Our Reference: PA-0004779/02
Customer reference: 3/2026/0238
Date: 22 July 2026

Approval of details reserved by conditions 3 (construction management plan/method statement) 4 (surface water) 5 (bat boxes) 7 (street maintenance) 8 (flood mitigation) 9 (flood management plan) 10 (surface water/foul drainage) 19 (cycle storage) 20 (travel plan) and 21 (operation/maintenance manual) on planning permission 3/2022/1158 granted on appeal APP/T2350/W/25/3368139.

Land South of Accrington Road, Whalley

Condition 8 – Flood Mitigation

COMPENSATORY STORAGE SECTIONS

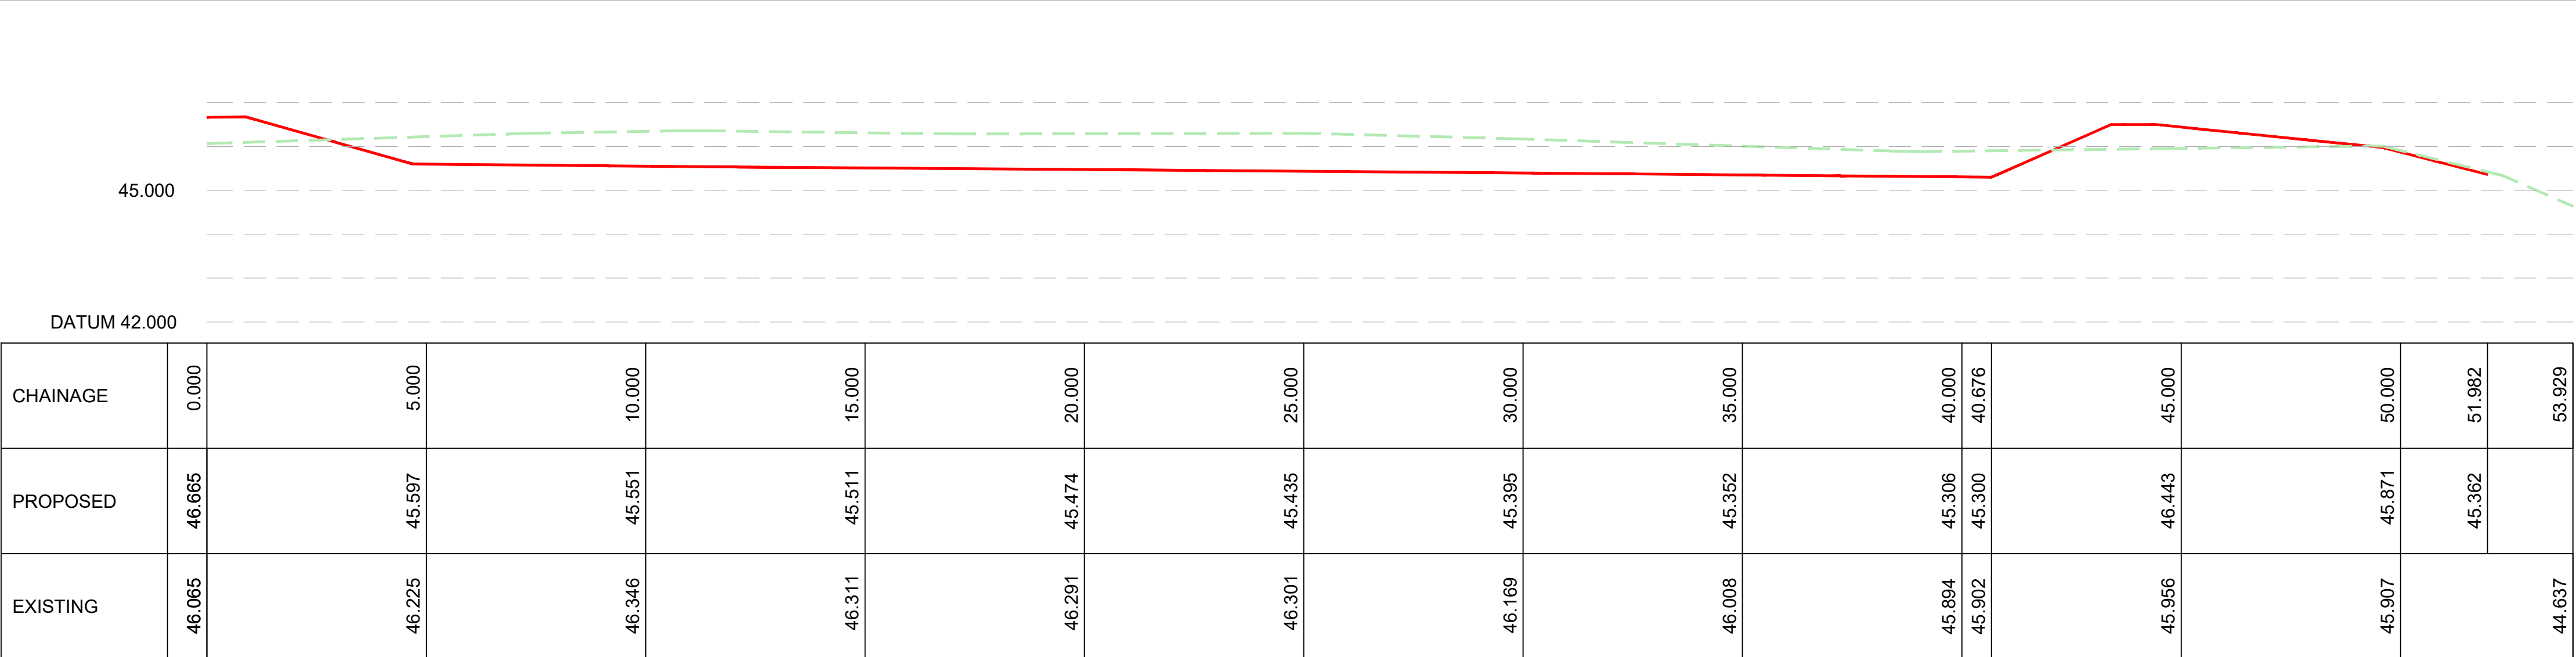
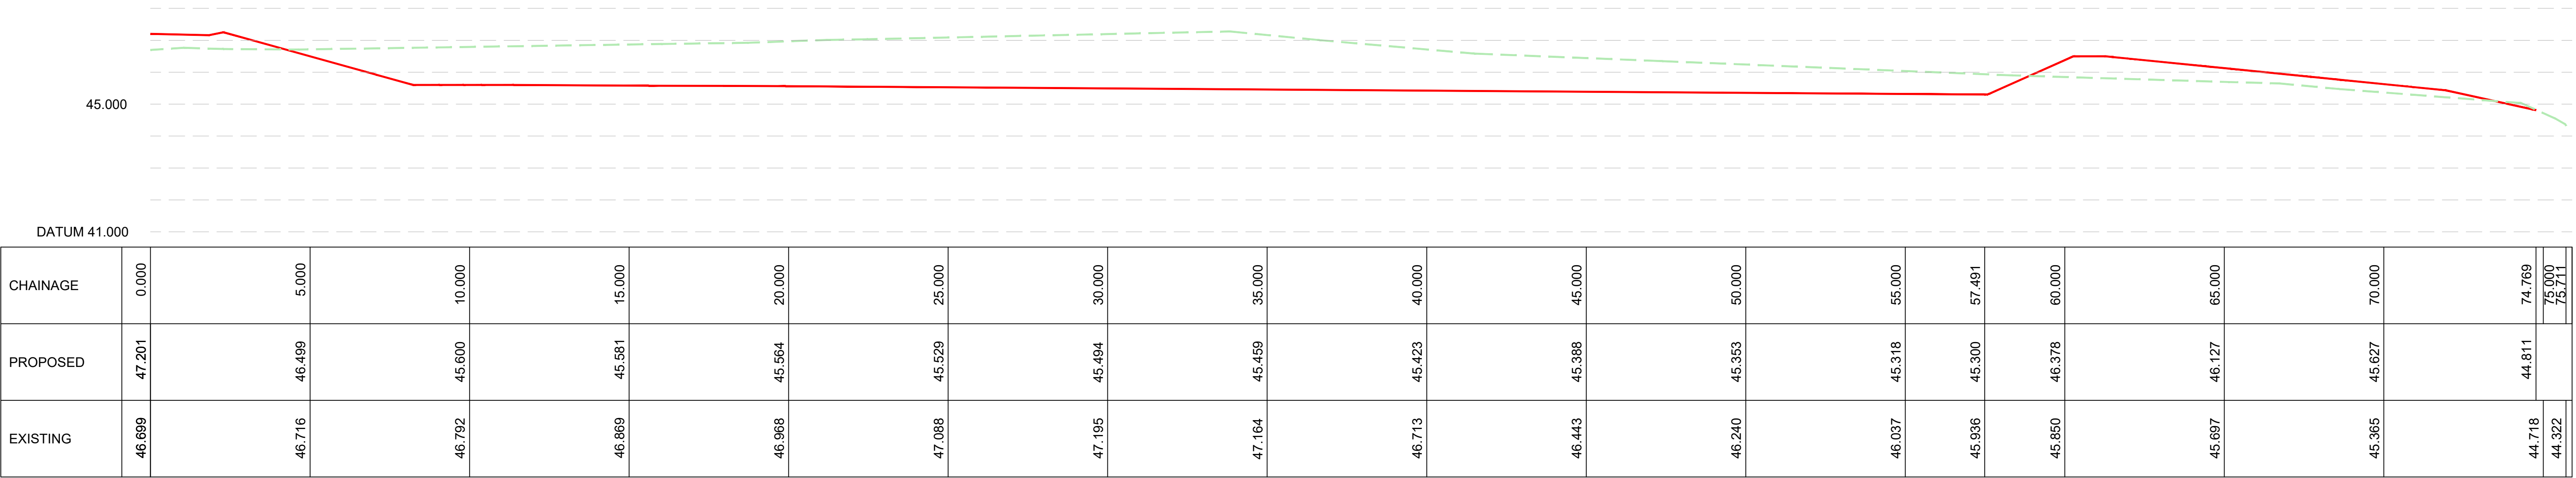
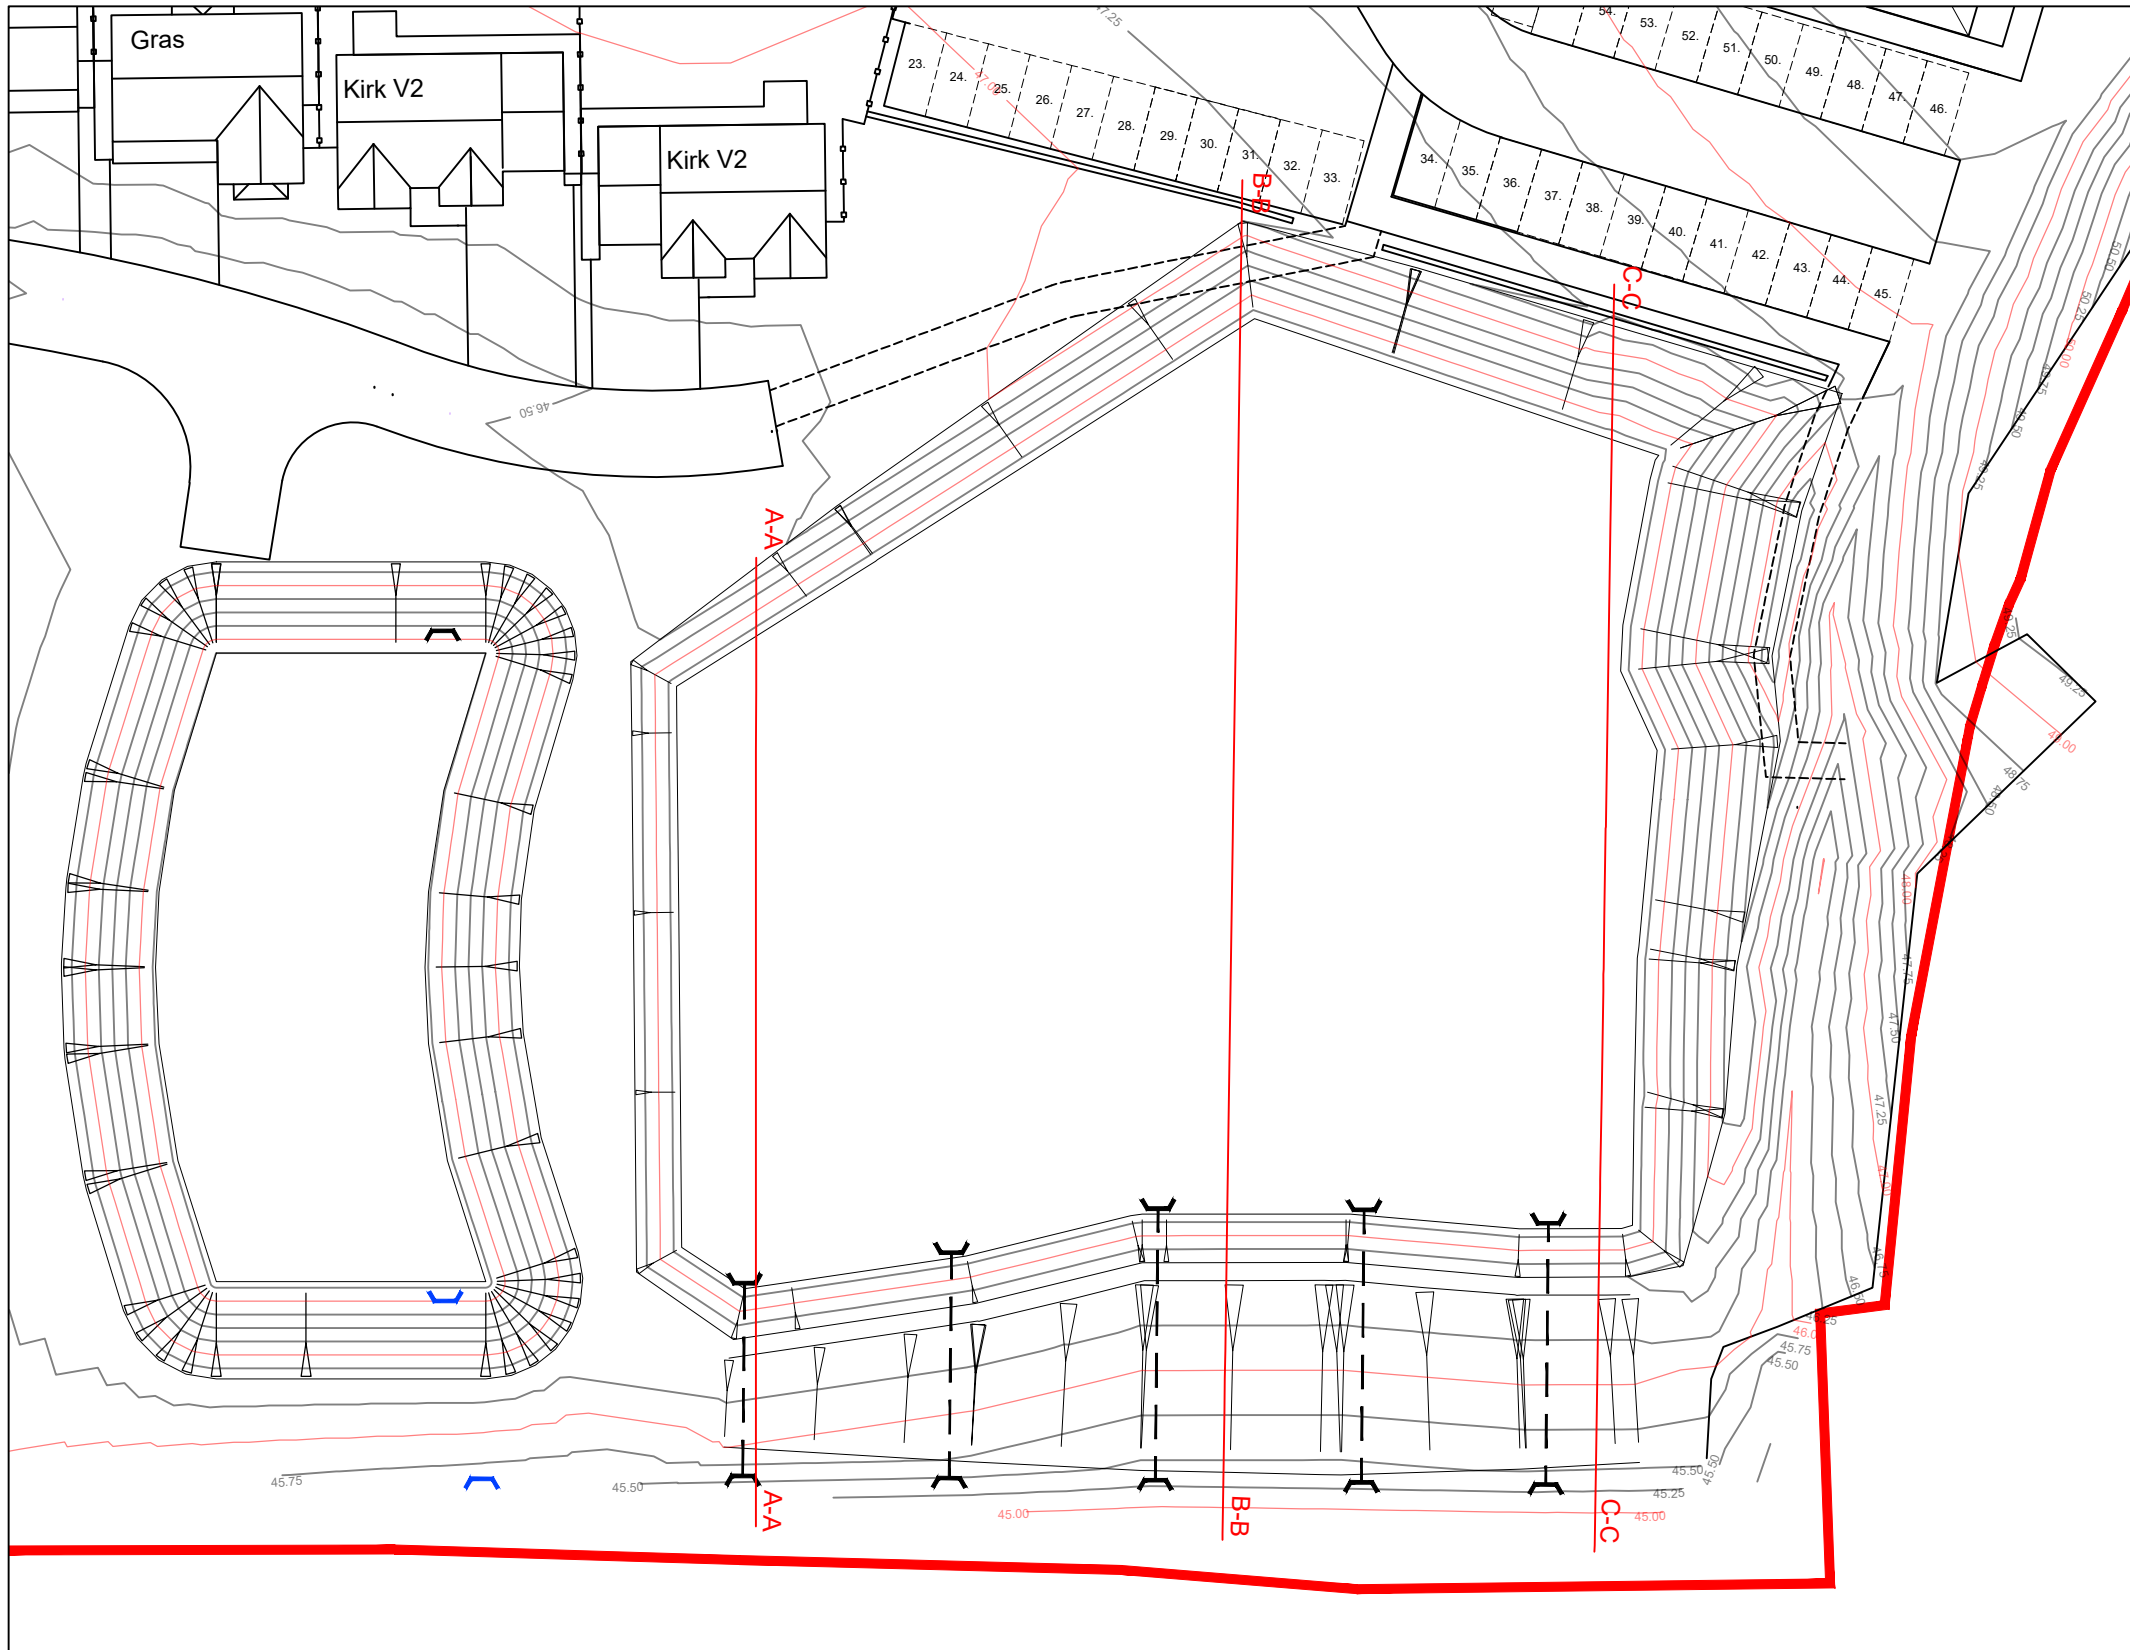
information largely comprises material previously reviewed by the Environment Agency as part of the original flood risk assessment and hydraulic modelling work and does not represent a materially updated or substantially more detailed engineering design for the compensatory flood storage proposals.

"The plans submitted shall show the final engineering solution for the compensatory storage measures, including (but not limited to) the detailed design and hydraulic modelling to demonstrate how the scheme will function to ensure flood waters can enter the storage and be discharged freely after a flood."

As set out in our previous response, the condition requires the submission of the final engineering solution, supported by detailed engineering design and hydraulic modelling demonstrating how the compensatory flood storage area will operate during a flood event and subsequently drain following flood recession.

The information submitted to date does not provide sufficient detail to demonstrate this. In particular, detailed design drawings, engineering sections, construction-level details and supporting hydraulic evidence have not been provided.

Noting the lack of design update for the proposed compensatory flood storage area we would reference the current proposals for 225mm diameter drain down pipes against CIRIA C786 – Culvert, Screen and Outfall Manual (2019) guidance. C786 includes minimum recommended culvert dimensions and identifies 450 mm diameter (or equivalent height) as the minimum recommended size for small culverts, principally to reduce blockage risk and facilitate inspection and maintenance.

C786 also promotes a risk-based approach to the assessment of blockage, debris loading, maintenance requirements and consequences of failure. The guidance recognises that reductions in flow area and the introduction of screens or control structures can increase blockage susceptibility and therefore require careful consideration.

We would recommend further consideration of these concerns for the required detailed design work.

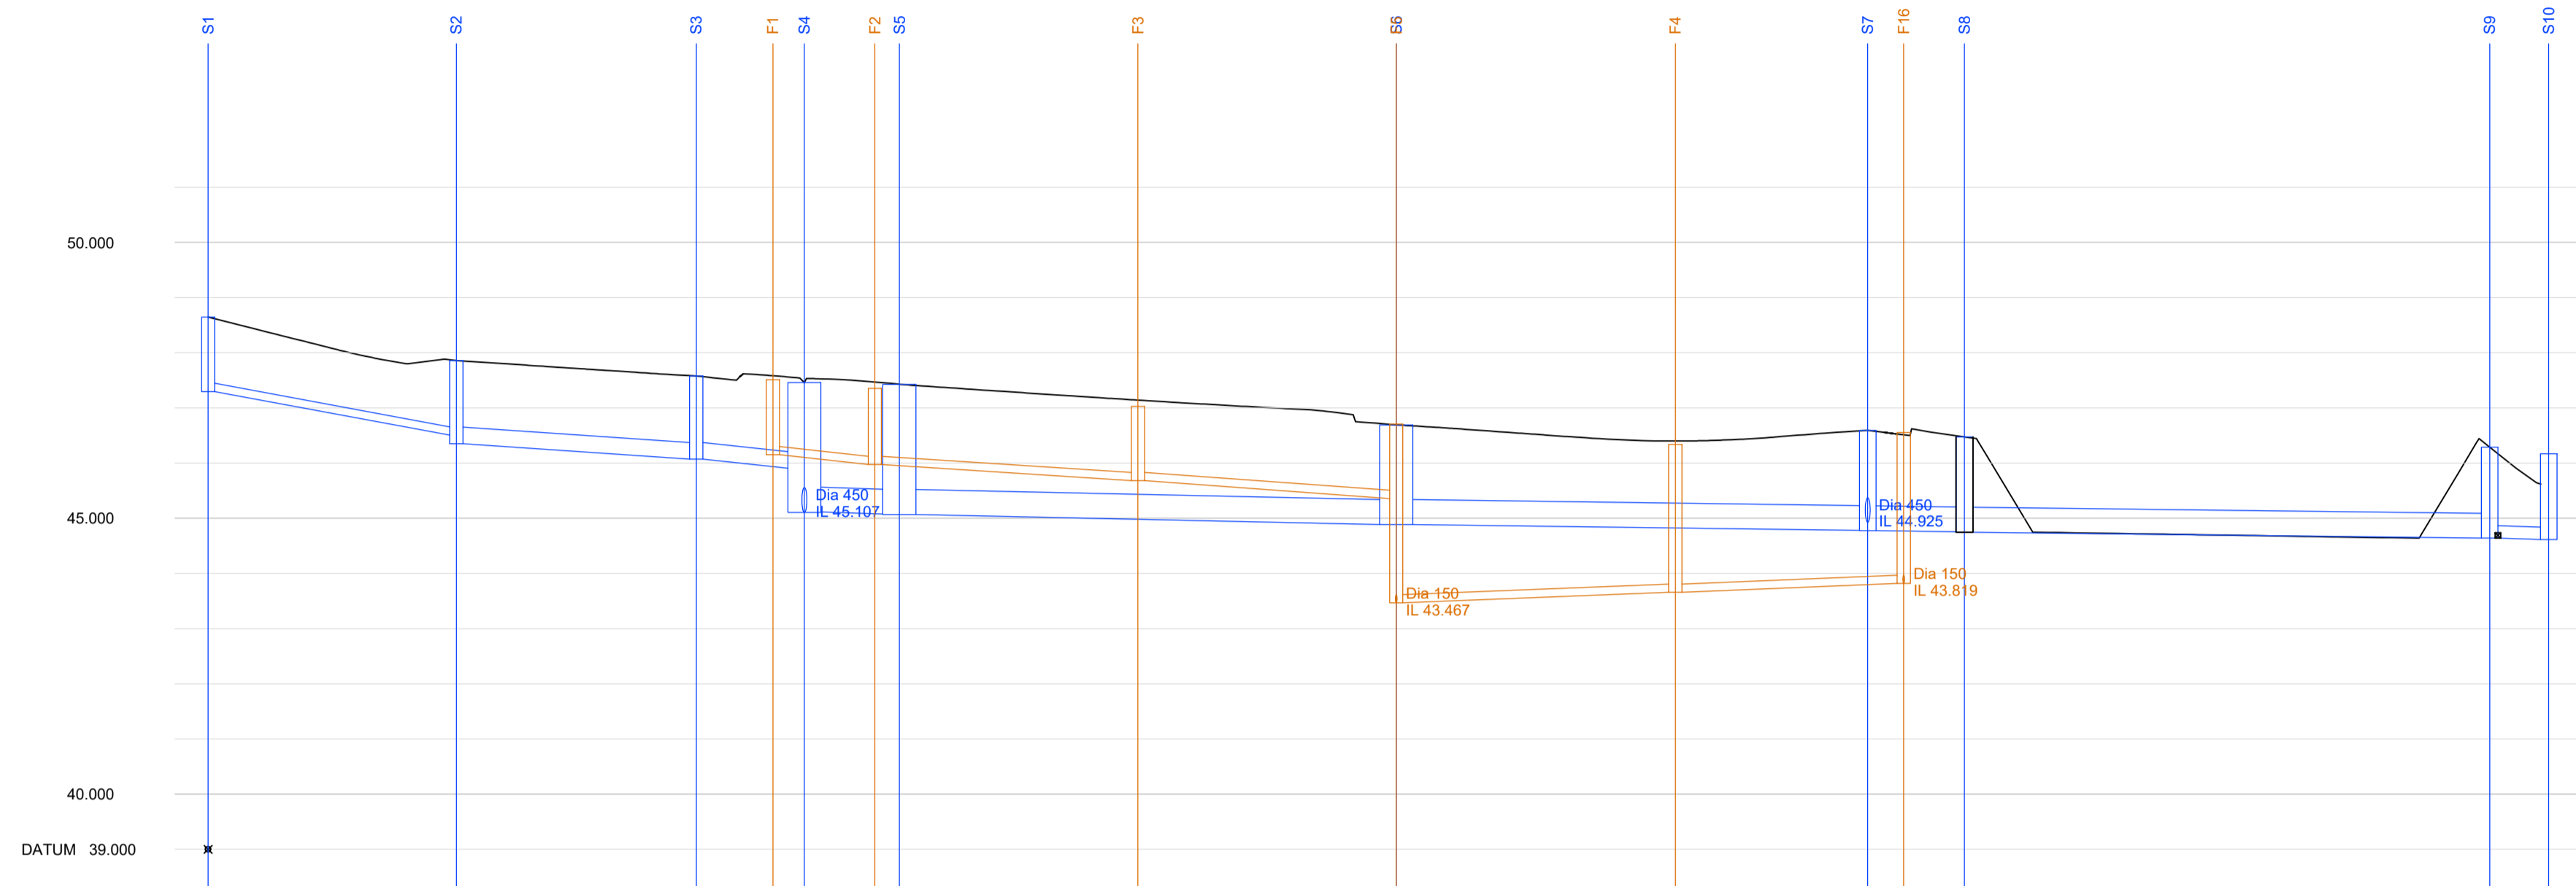
We have now reviewed the additional documents submitted, including the hydraulic modelling note, drainage layout drawing and drainage strategy information. This
